**Fire Suppression System Permit Application 2017-00019 - 1 Thompson's Point**4 messages

RE: Fire Suppression System Permit Application 2017-00019 - CBL: 201 A005001  
1 Thompson's Point

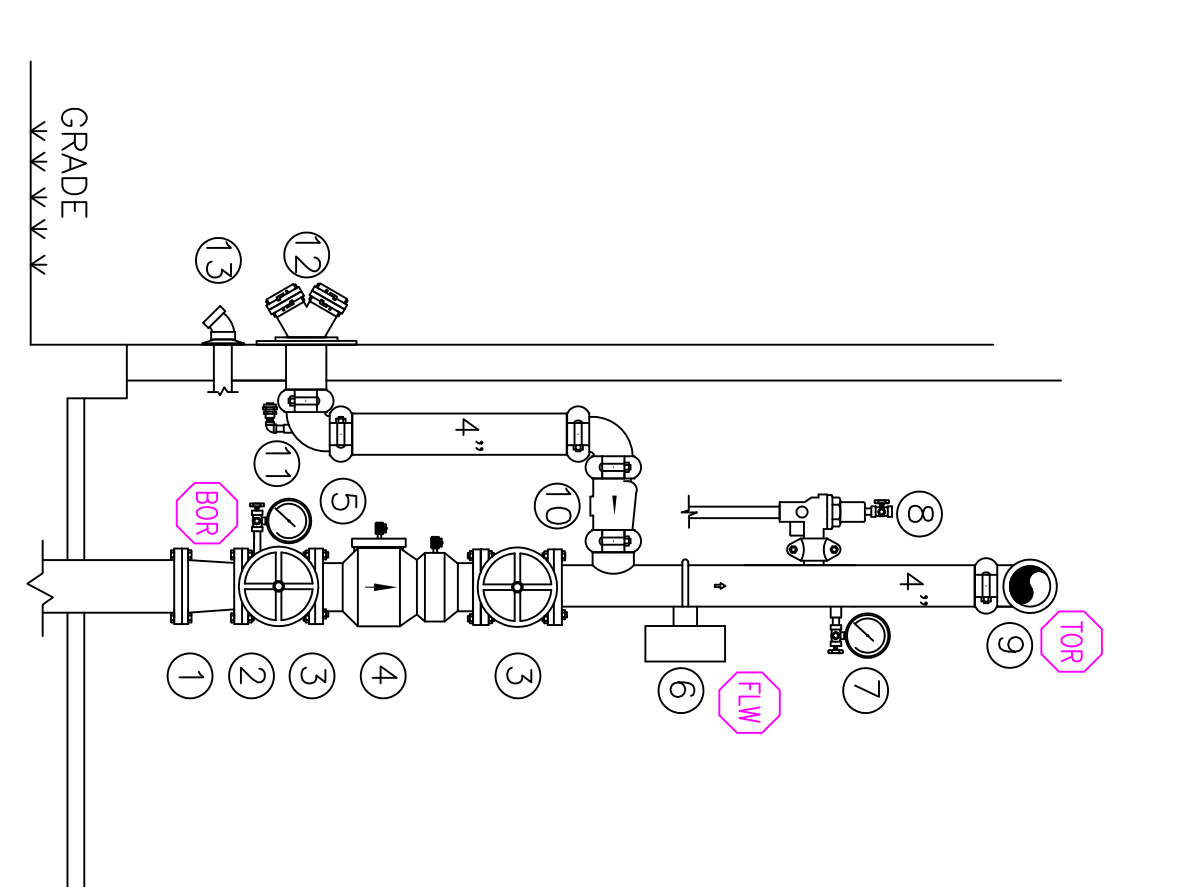
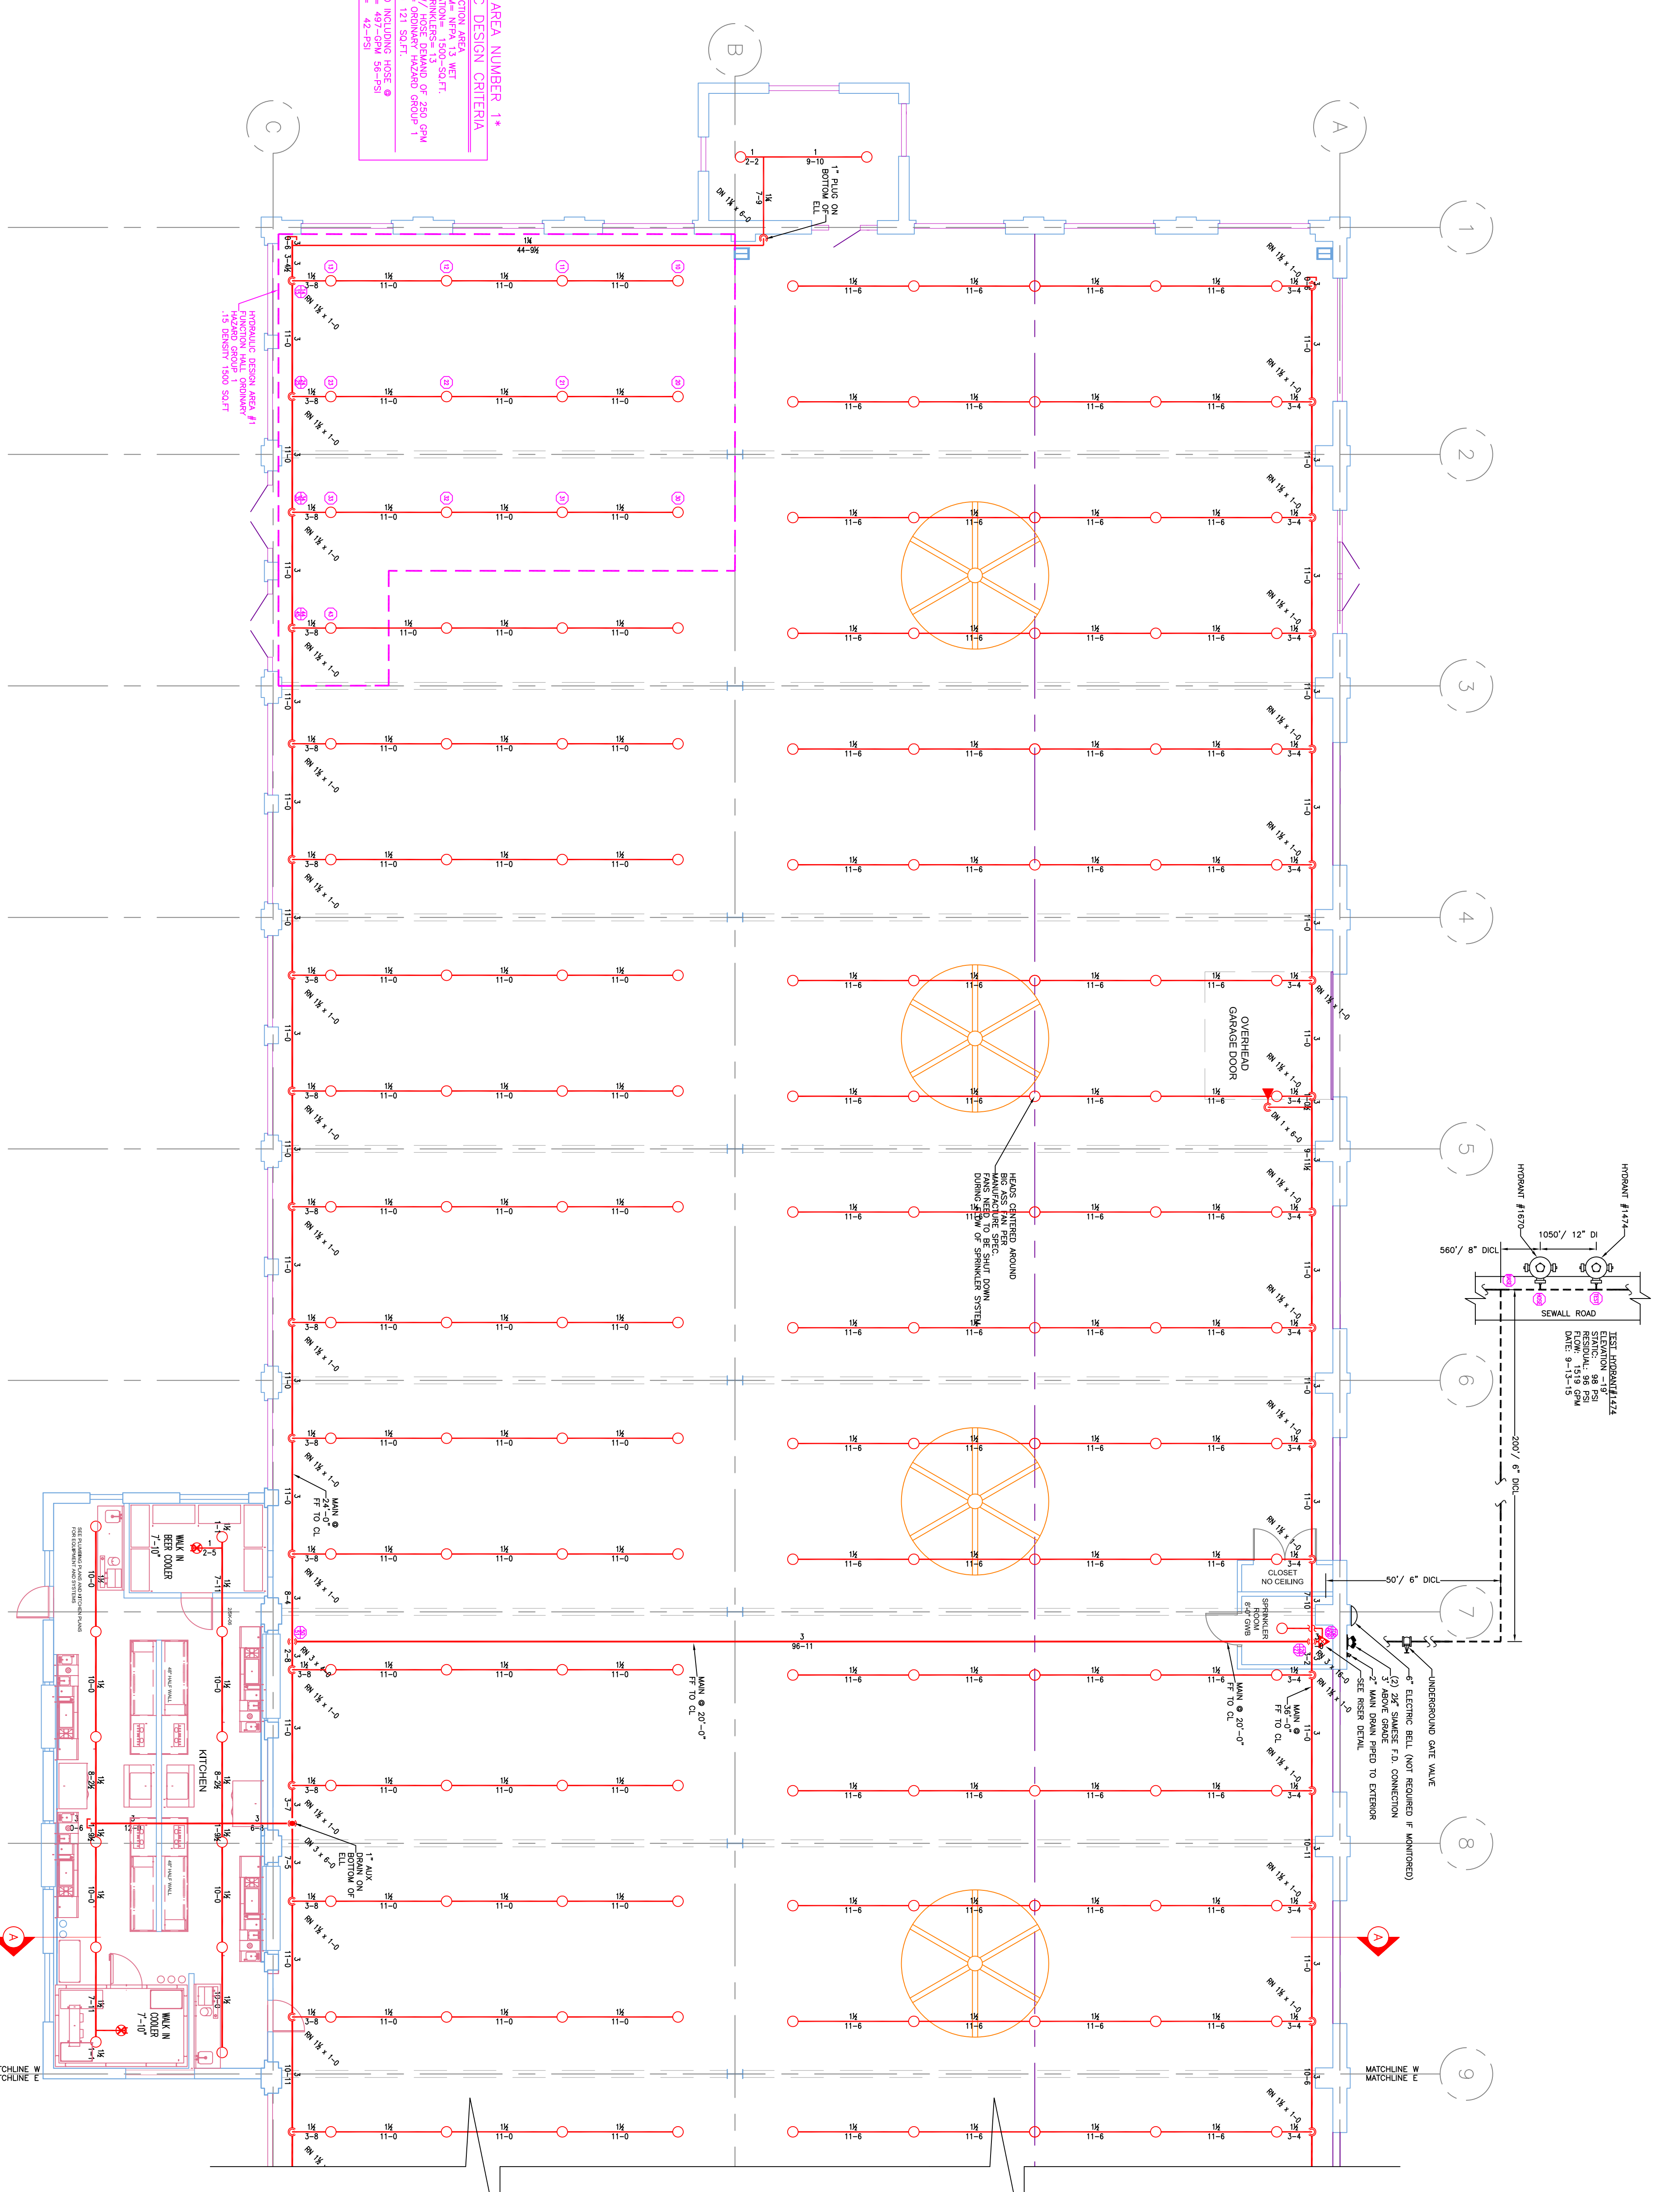
It turns out that the drawings you submitted were two separate sprinkler plans.

One pair of drawings called for protection of the vertical columns by the sprinkler system, the second pair of drawings did not have that protection.

If there was a change to the drawings the new version should have been submitted with the same name so that the old drawings could be updated.

Also, there was a question as to whether it is necessary to have thermal, and intumescent protection of the steel components.

These drawing show the steel beams in the building being protected via the fire sprinkler system feed.
